# Rezoning Transportation Analysis

Petition Number: #2023-018

**From:** Jake Carpenter, PE

Date	Description
06-22-23	First Review (TM)
11-27-23	Second Review (ME)

RZ-1

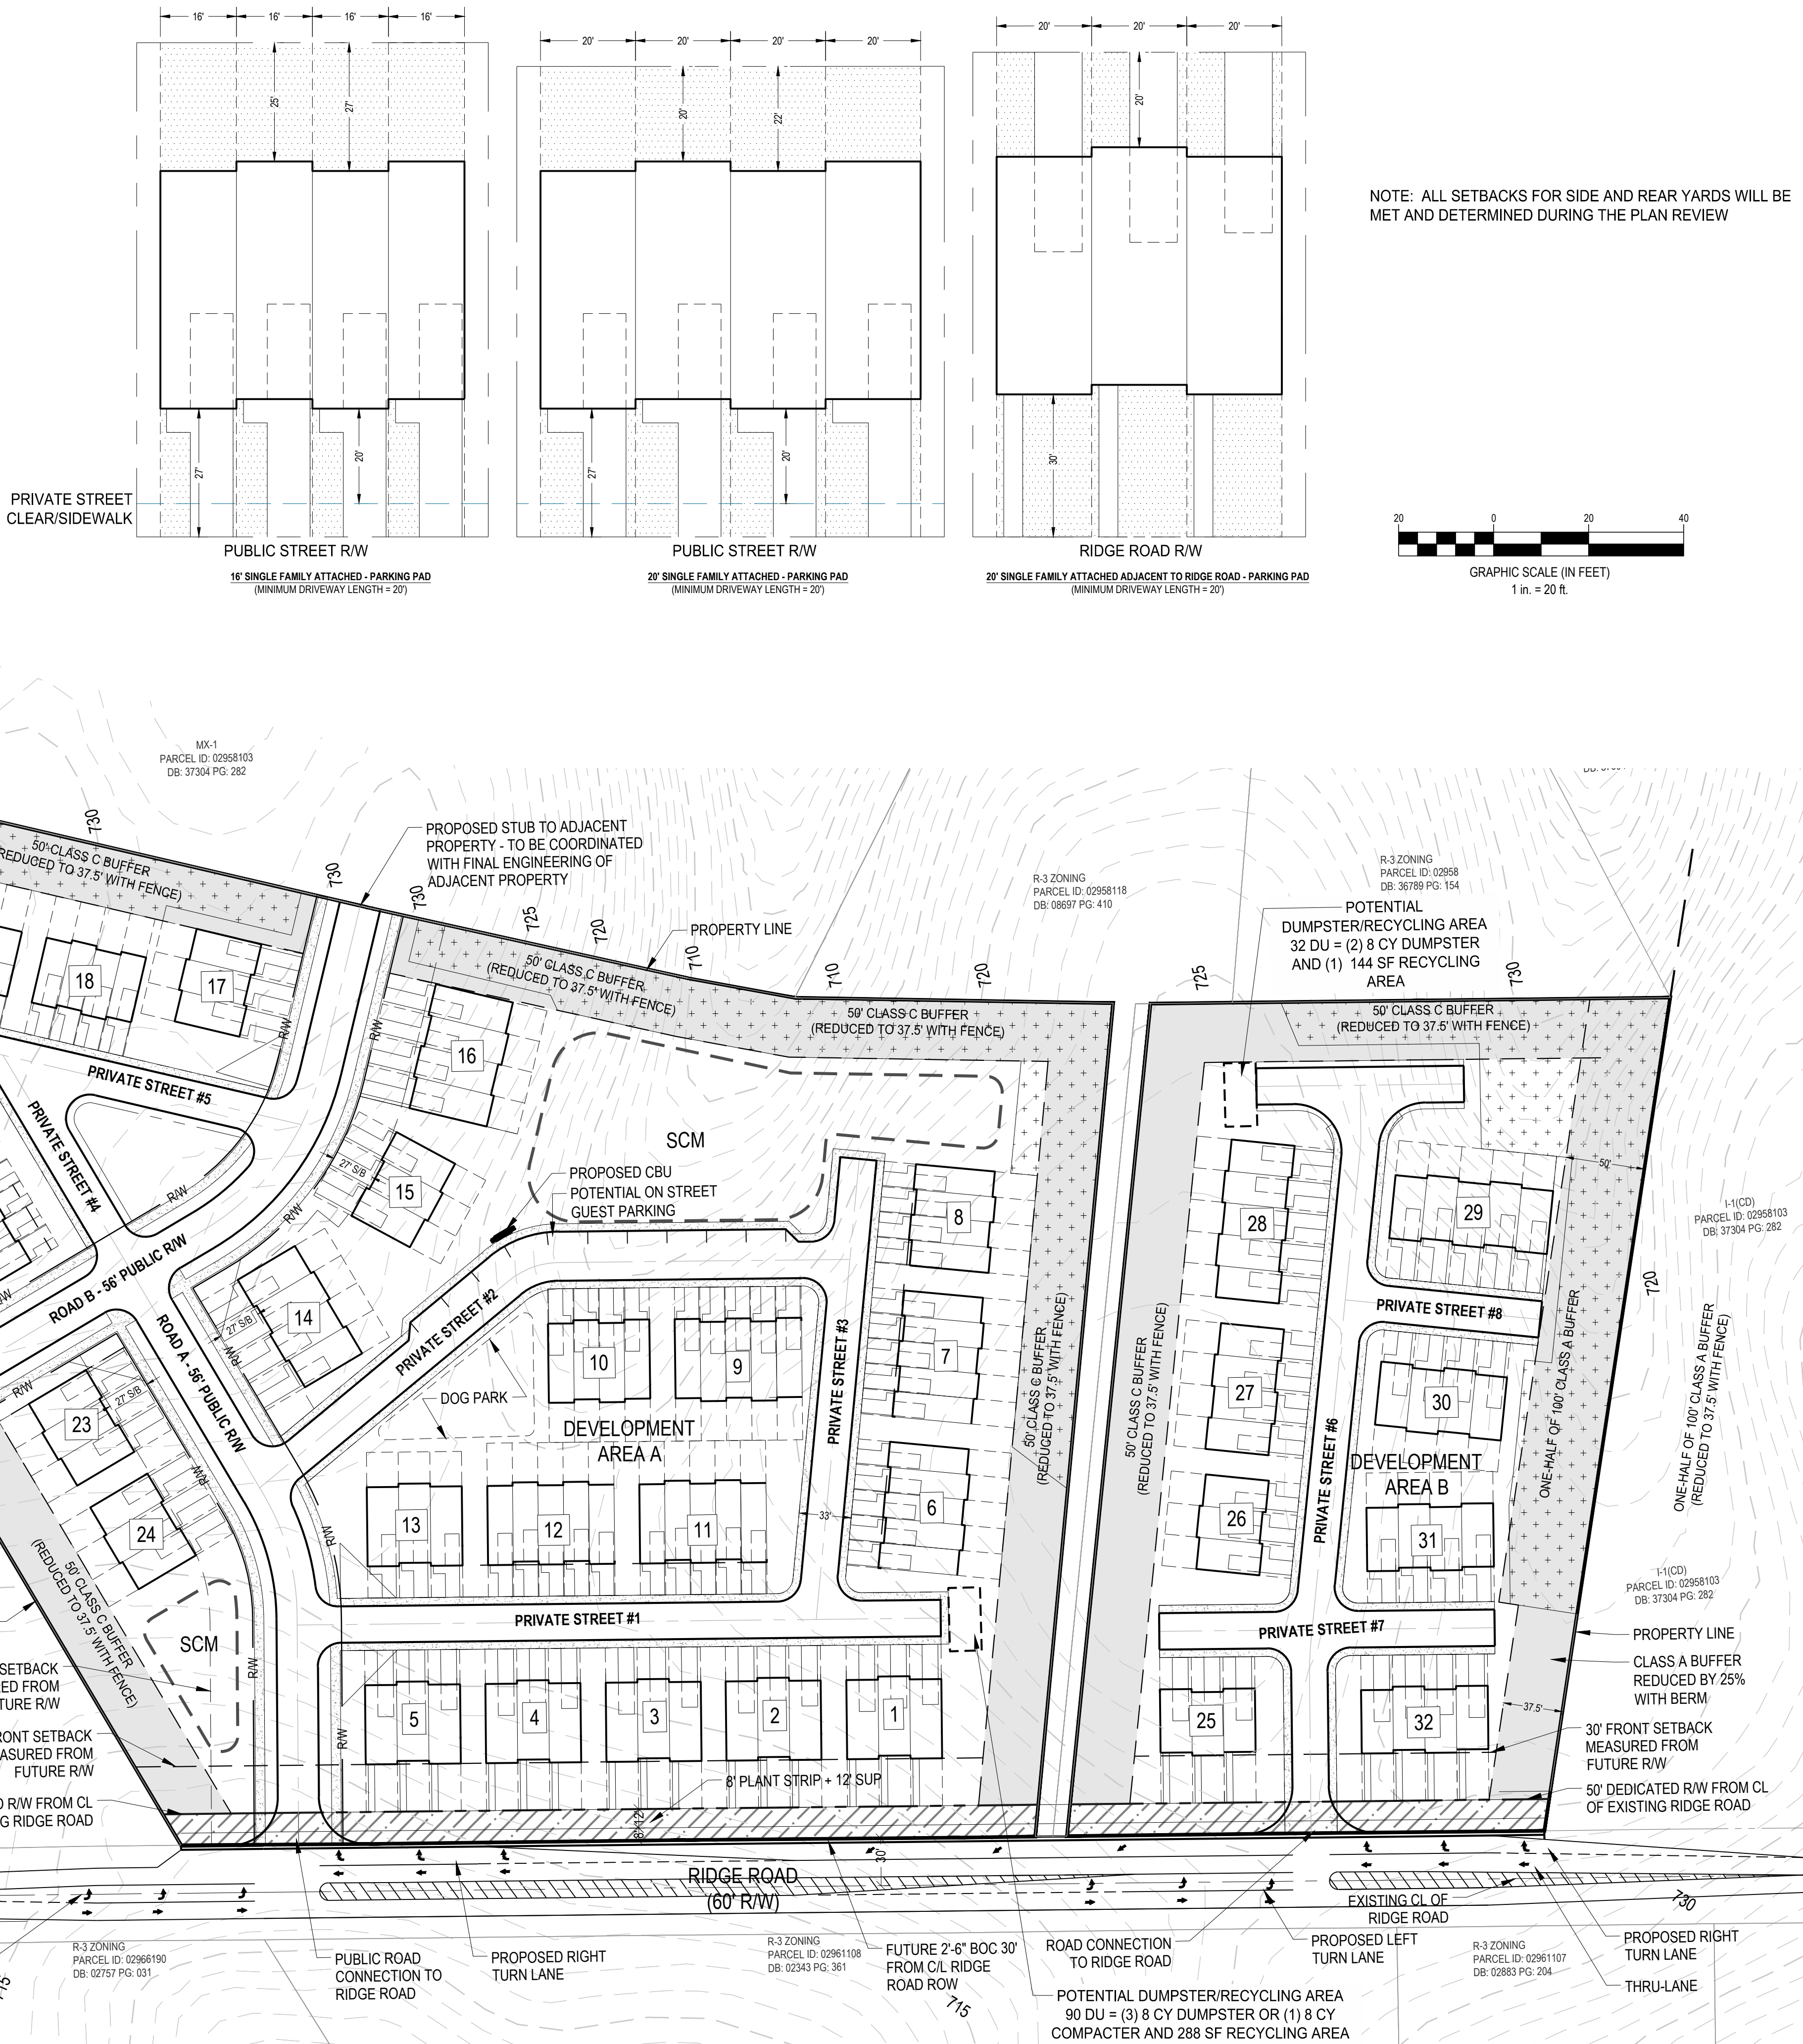
**Comment 11-27-23:** Site plan does not show two way left turn lane, please adjust to show this on the site plan.

**Comment 11-27-23:** Please revise site plan to show that 12 ft SUP is not within public right of way. The dedicated right of way callouts should also be revised to show that 38 ft is dedicated to the public and not 50 ft. SUP may be constructed within the right of way if the site is annexed into the City.
